**SSD 7484 – MODIFICATION 4 RESPONSE TO SECOND REQUEST FOR FURTHER INFORMATION
23-33 & 35-39 BRIDGE STREET, SYDNEY – THE SANDSTONE PRECINCT**

This Response to Second Request for Further Information has been prepared by Ethos Urban on behalf of Pontiac Land Australia (Pontiac) to address comments from the Department of Planning, Industry and Environment (DPIE) relating to modification application (Mod 4) to State Significant Development 7484 (SSD 7484) which relates to the development of tourist and visitor accommodation at the Sandstone Precinct, Sydney. Additional comments were also received from authorities.

**EES comments: Sandstone Precinct Stage 2, SSD-7484 MOD 4
Response to Environment, Energy and Science Group (EES)**

DRAWING TITLE
**PROPOSED COURTYARD ELEVATIONS
LANDS BUILDING - NORTH COURTYARD**

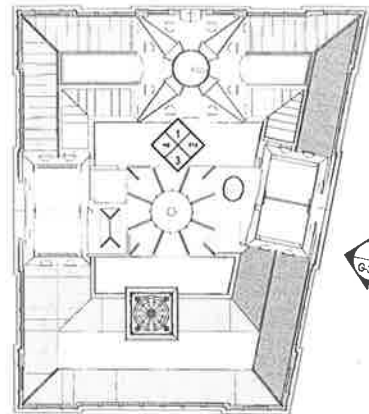
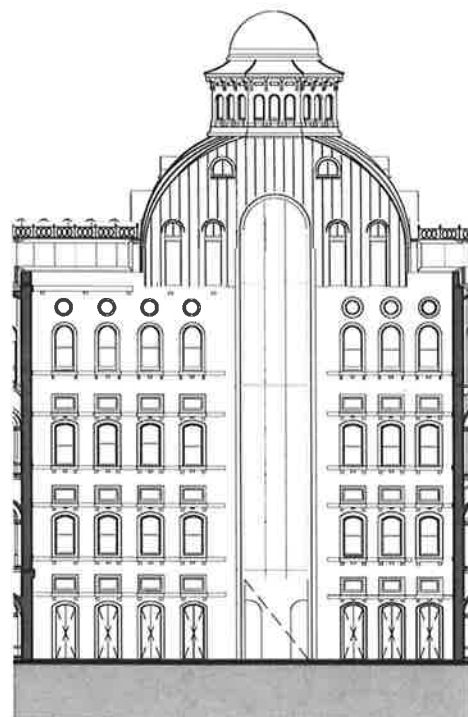
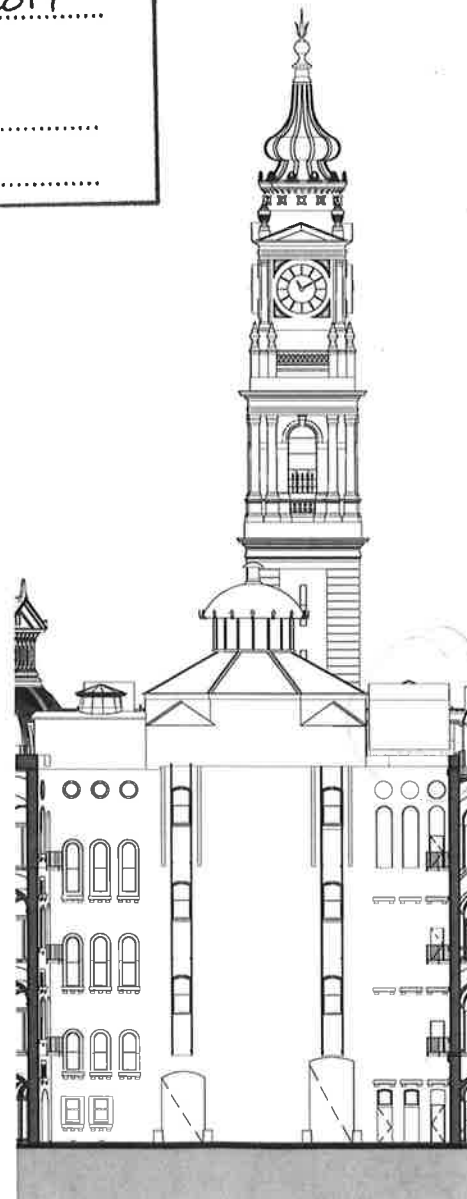
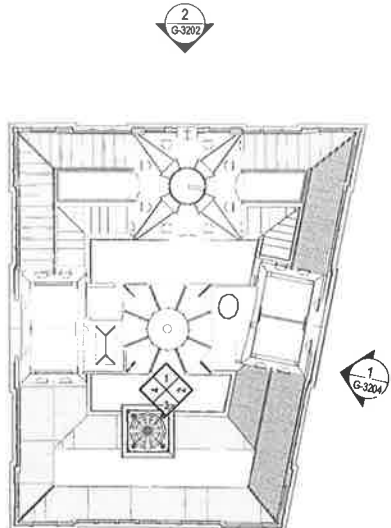
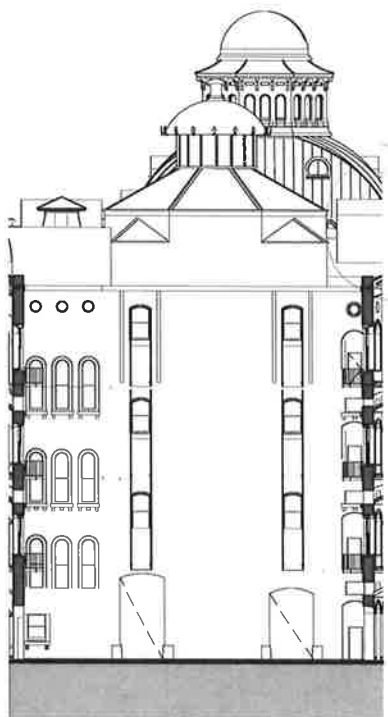
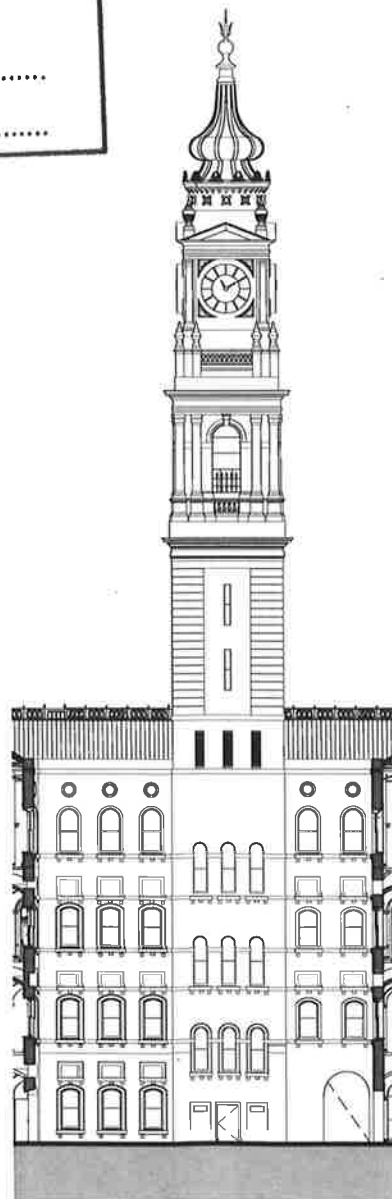
Environment, Energy and Science	Response
Where the growing conditions in the courtyard and rooftop allow, it is recommended local native provenance plant species are used rather than exotic species and non-local native species.	See attached response from Hassell at Attachment A . In Hassell's view the use of a combination of local and non-endemic native species is in this situation considered to be appropriate given the context, plant profile, soil profile, solar access and heritage considerations.

Tree and groundcover species identified in the Hawesbury Sandstone community typically require a full sun position for health and vitality. The linear courtyards (7 x 26m) are situated 27m below roof level and consequently receive less than 2 hours of direct sunlight on the summer solstice – this is insufficient solar access to support the health of the endemic species mix.

A collection of shade tolerant endemic species from surrounding ecological communities have been incorporated into the courtyard design including *Adiantum*, *Asplenium*, *Brachyscome*, *Dendrobium*, *Ficus*, *Licuala*, *Lomandra*, *Pratia*, *Platycerium* and *Scaevola* species.

We would request the recommendation is revised, taking into account the considerations of site suitability outlined above. Noting the design will aim to use species endemic to the surrounding Sydney Harbour foreshore ecologies in combination with other environmentally suitable species to deliver a quality landscape outcome.
